# London Luton Airport Expansion

## Buckinghamshire Council Comments on Further Deadline 4 Submissions

**PINS REFERENCE:** TR020001

**November 2023**

Figure 9.1: Community First zone

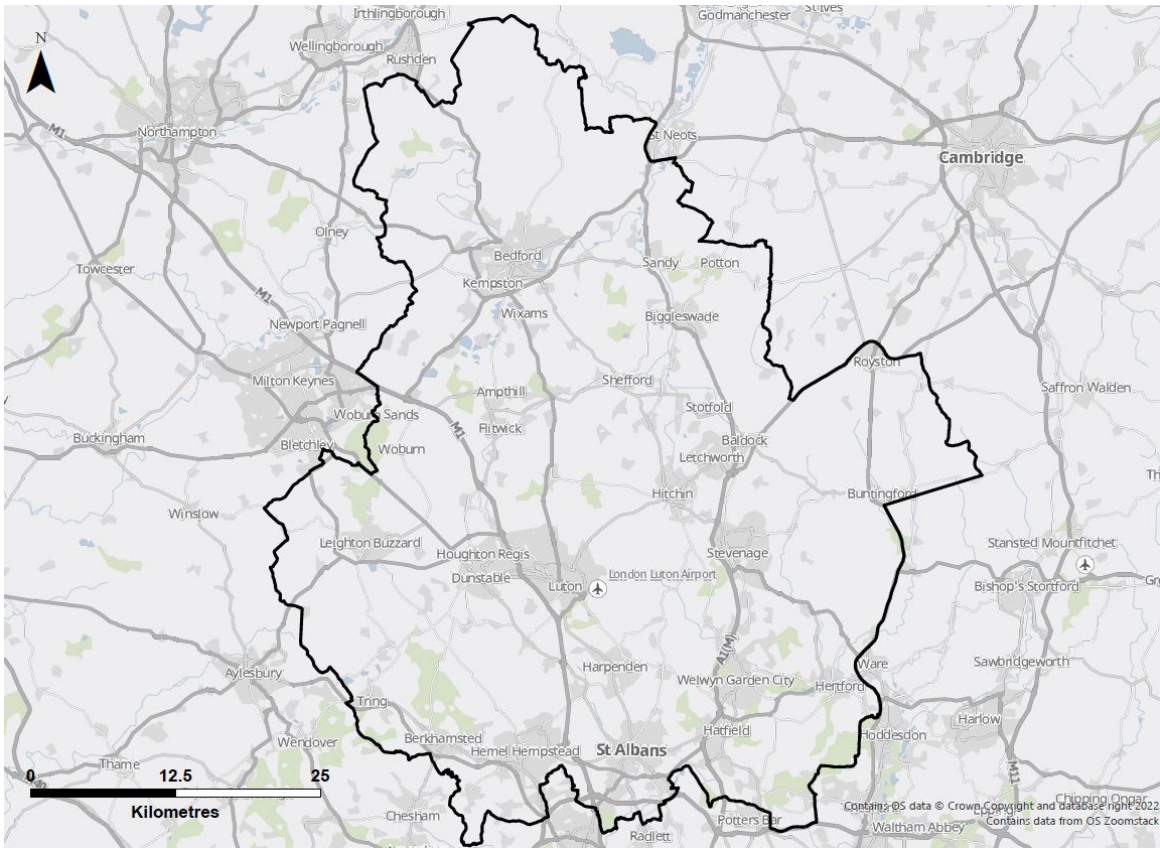
2.24.1. The Council welcomes the expansion of the Community First zone to include the four additional wards in Buckinghamshire (paragraph 9.1.2 and figure 9.1). The Council is aware that Central Bedfordshire Council has raised the lack of detail relating to the Community First Scheme as an issue – the Council agrees that more detail would be helpful but accepts that this is unlikely to be forthcoming until the administering body is appointed.
